Application for Planning Permission

73 Keith Road

PROPOSED DOUBLE STOREY SIDE EXTENSION, PART SINGLE PART DOUBLE STOREY REAR EXTENSION FOLLOWING DEMOLITION OF AN EXISTING GARAGE TO CREATE 1NO OF 2 BEDROOM SELF CONTAINED DWELLING

26923/APP/2026/1681

Title:	
Proposed First Floor Plan	
Site Address	Scale: 1:50 @A3
73 Keith Rd, Hayes. UB3 4HP	Date: 11/09/2026
	Drawing No.: 2025/185 -04NB
	Drawn By: RO
Revision Date:	Faluck Patel
e:mail - faluckpatel@yahoo.com (M) +44 (0) 7871 466 254

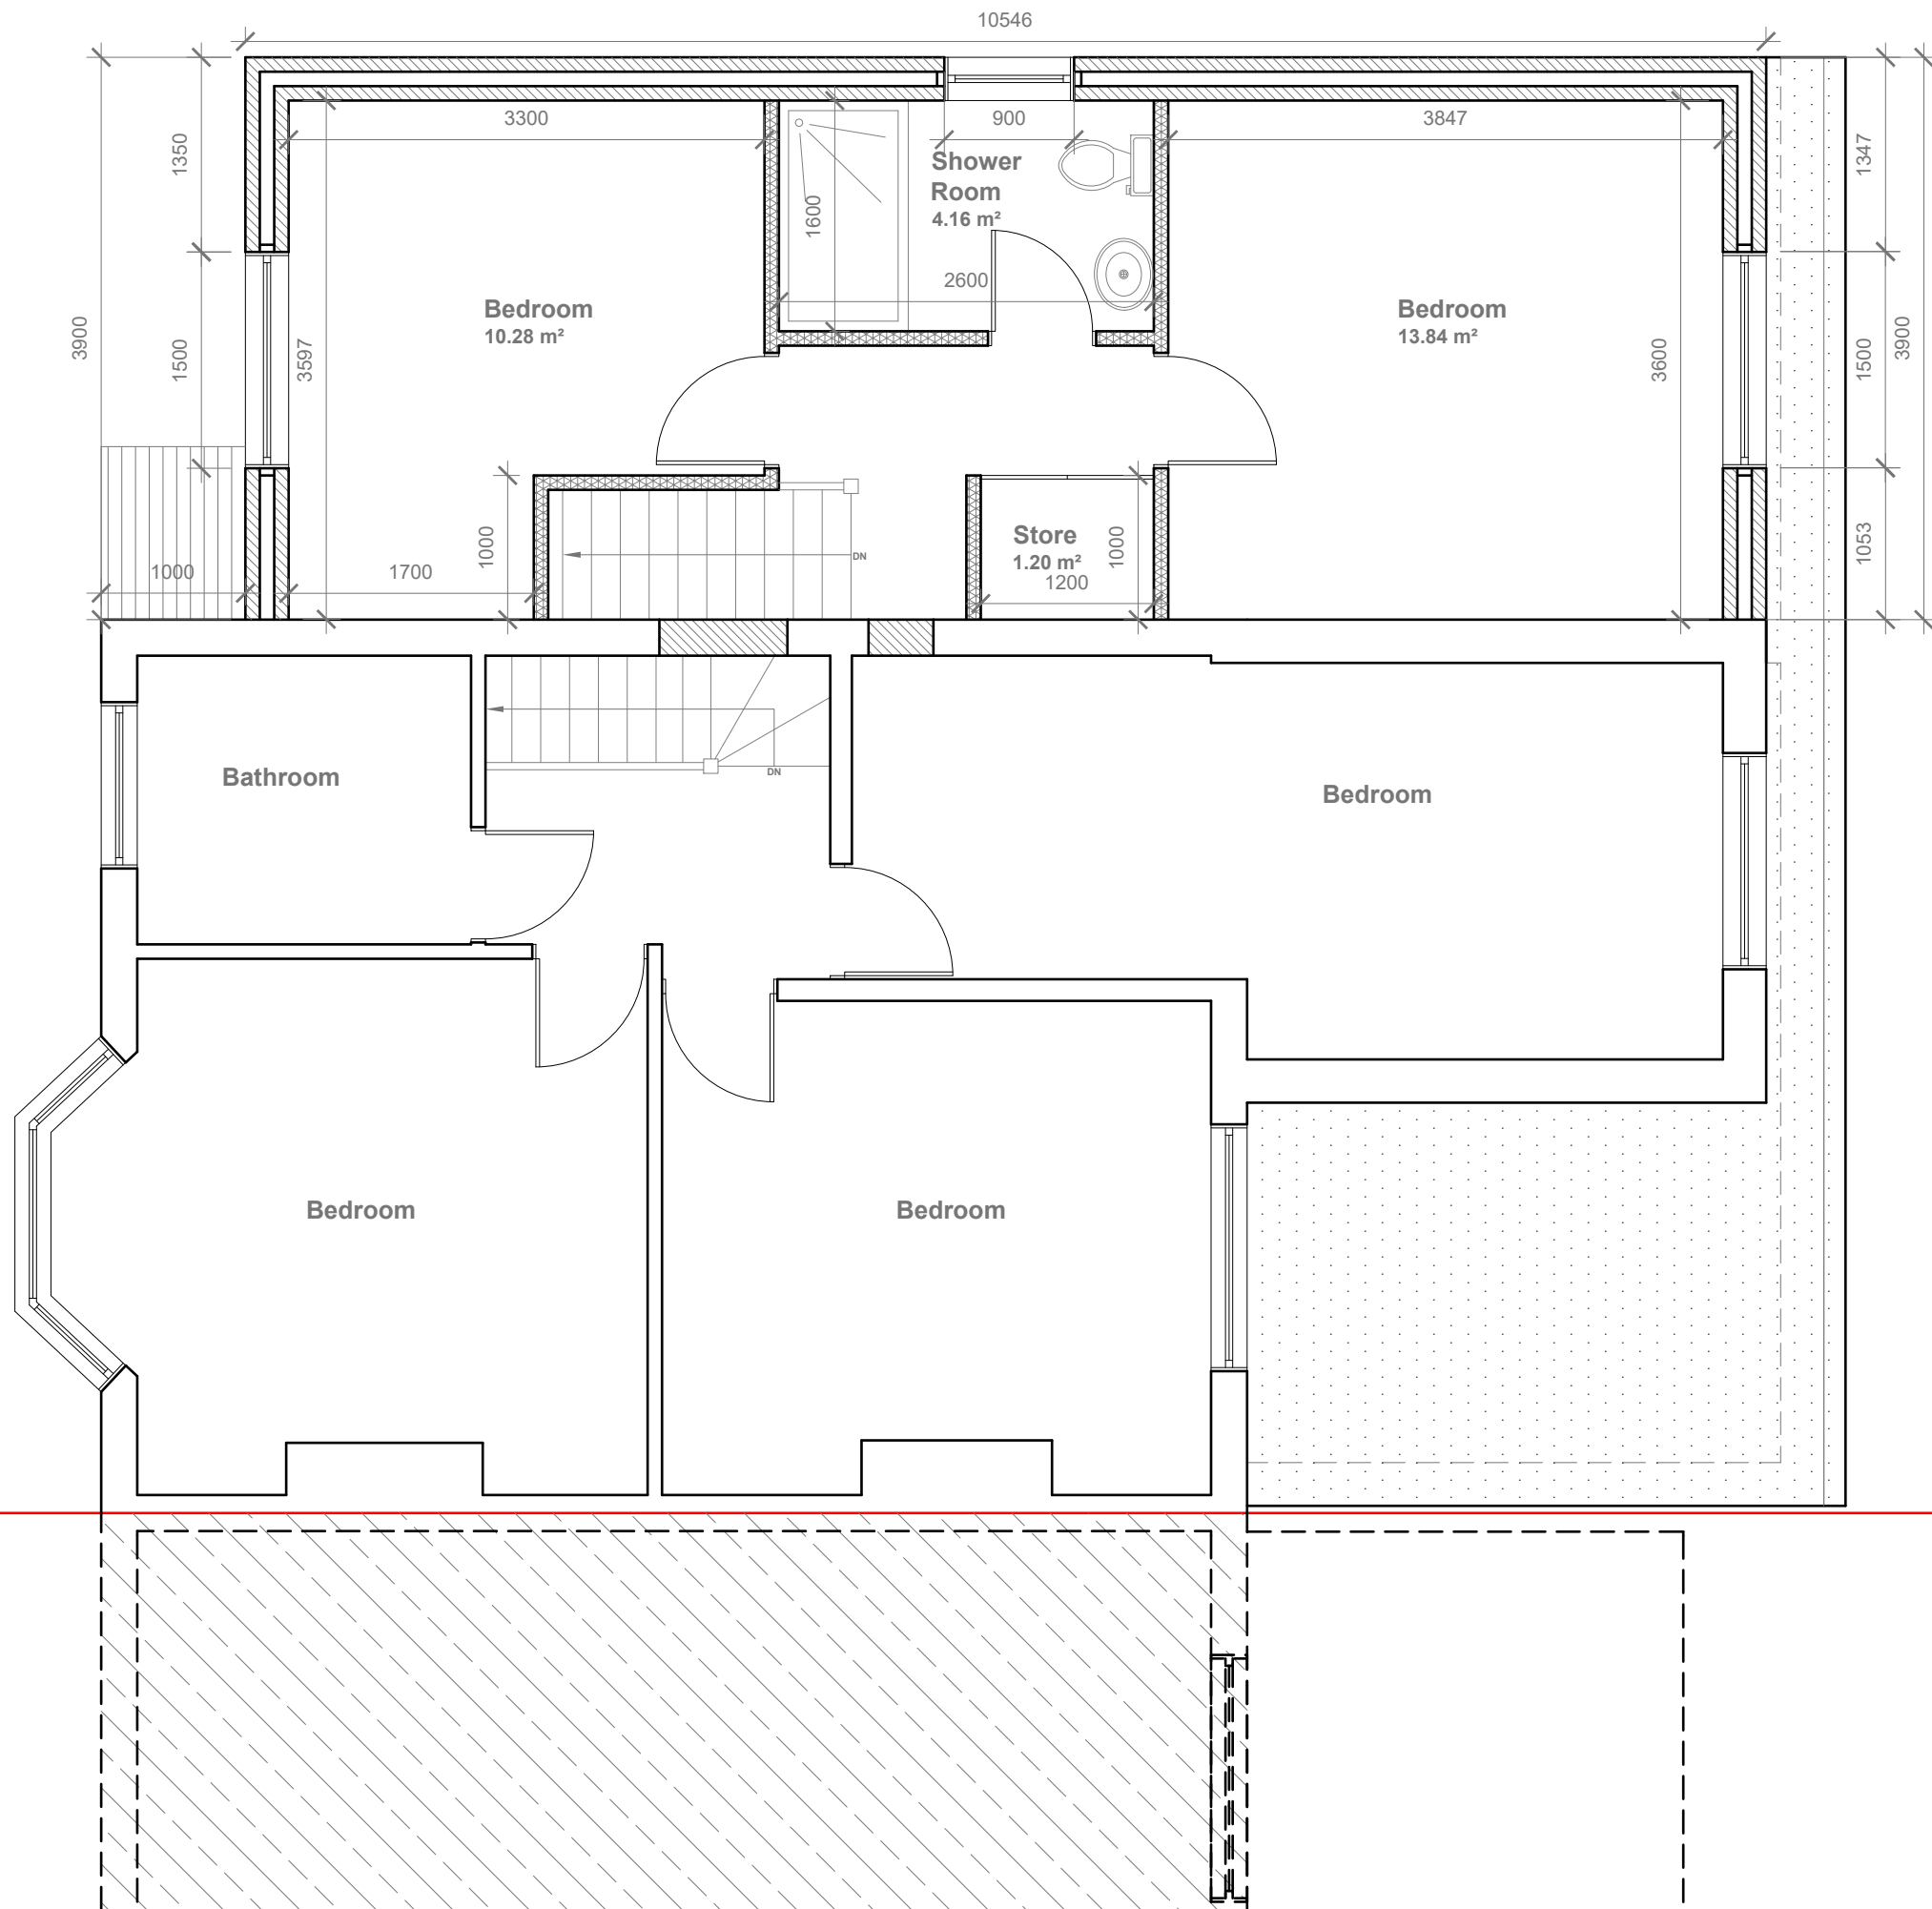
Can I just ask that details are submitted to reinstate the redundant vehicle crossover to footway and slightly reduce the smaller bedroom in size to a single room as a 73sq.m overall GIA would comply with the minimum space standards for a 2bed 3person dwelling but not a 2bed 4person dwelling. It would also be helpful to annotate the size of the retained garden area for the host dwelling on the site plan.
